## DECISION DELEGATED TO HEAD OF PLANNING

**Application No:** H16-1099-22      **Applicant:** M R & C M Senior  
**Proposal:** Installation of photovoltaic panels to south & west roof slopes  
**Location:** 33 Red Lion Street Spalding  
**Terminal Date:** 10th January 2023

WEST ELEVATION - PROPOSED

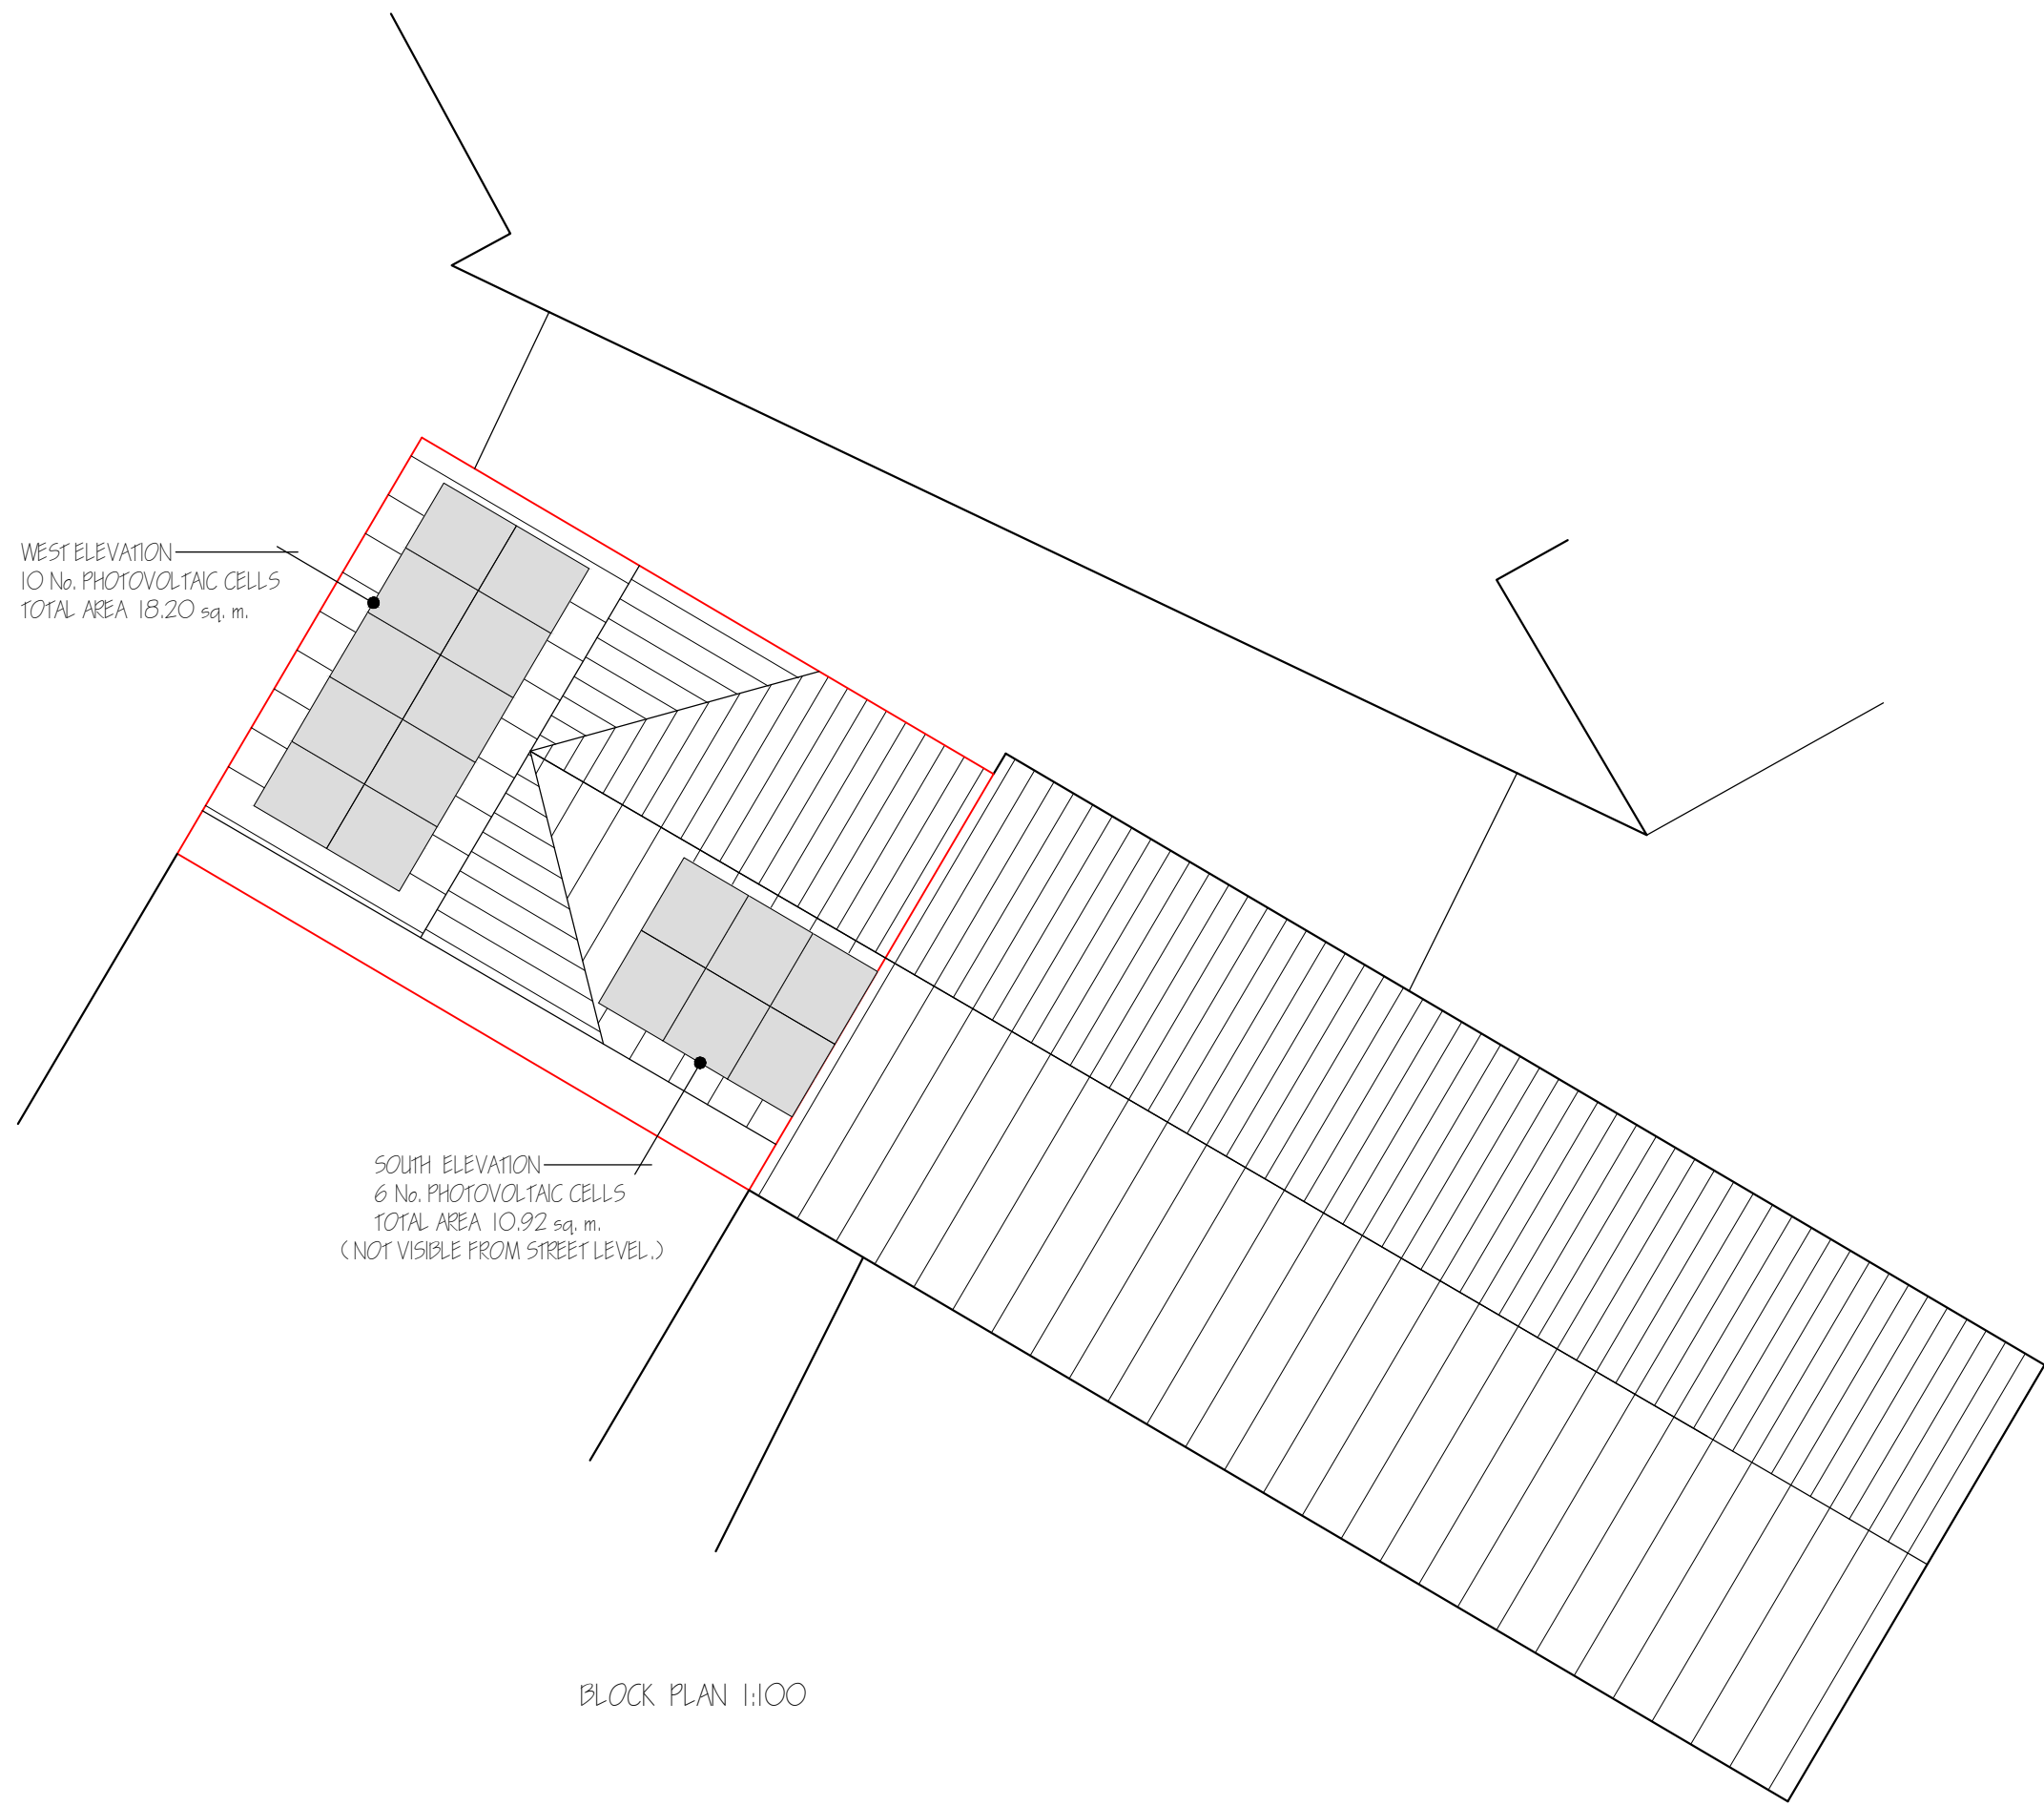
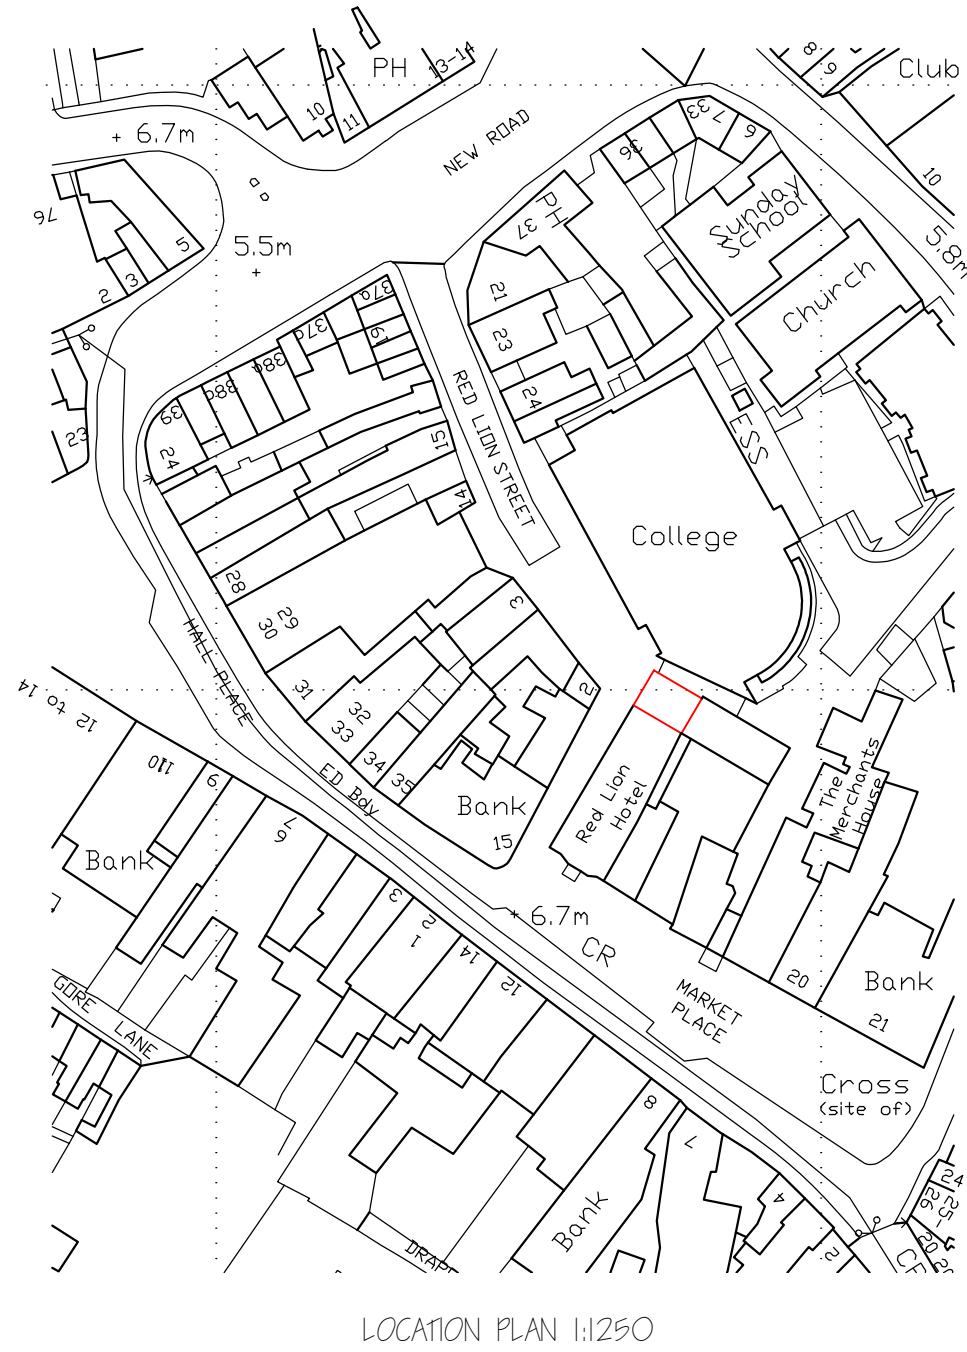
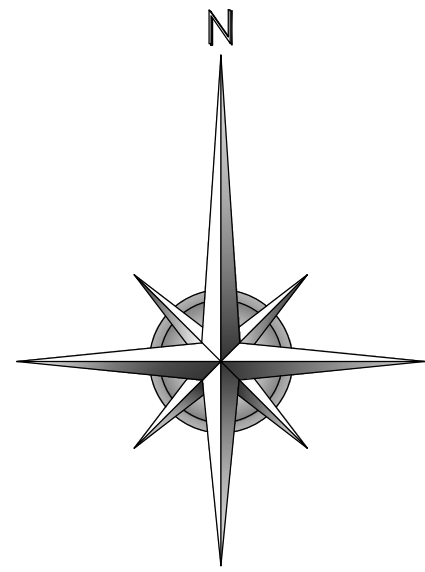
This proposal, by virtue of its intention to place modern photovoltaic cells on a highly visible elevation within a prominent section of the conservation area, fails to respect the standard of visible materials within this portion of the town centre and the slate roof of the host property, which is a common feature of this section of the Conservation Area.

Furthermore, the proposal does not seek to do anything to mitigate against the effect the proposal would have on the roofscape within the conservation area. The addition of photovoltaic cells would represent an unwieldy and highly visible addition to the rooftop and would risk generating a precedent of incongruous additions to visible roof pitches even within sensitive locations within the town centre and conservation area. The deployment of Photovoltaic within the conservation area may be possible, however, it would generally be expected that in all but exceptional circumstances, photovoltaic cells should be restricted to sections of roof not visible from the public realm or at least areas where the visual impact upon public realm views would be mitigated against."

The panels on the southern pitch will not be visible from street level, reducing their potential impact on the character of the area. However, the western slope, which fronts Red Lion Street, would be visible. As a result, the western slope, which would see the greater number of panels, would be an outlier in Red Lion Street.

The panels would cover the rooftops, leaving a small perimeter surrounding the array of panels. As the surrounding properties predominantly have slate roofing, a noticeable visual disparity would be created between the property and its' neighbours. This would directly contradict Policy 29 B, sections 2 and 5 of the South-East Lincolnshire Local Plan.

Evaluated against the above tests, the proposed works do conform to tests 2, 3, 4, 5 and 7. However, they fail to achieve the remaining criteria. The proposed works would damage the visual amenity of the conservation area and damage the local character. As outlined above, the proposal would have a dramatic impact on the settings of local heritage assets. Therefore, the proposed photovoltaic cells would not conform to policy 31 of the South-East Lincolnshire Local Plan.

As the proposed panels on the south would be obscured from view, the relative potential impact of this aspect of development is minor. There would be a visual disparity when viewed from above, however, at street level, the panels would have little to no impact. However, the western cells would dramatically negatively impact the character of the surrounding area and undermine the sense of place currently established in Spalding town centre.
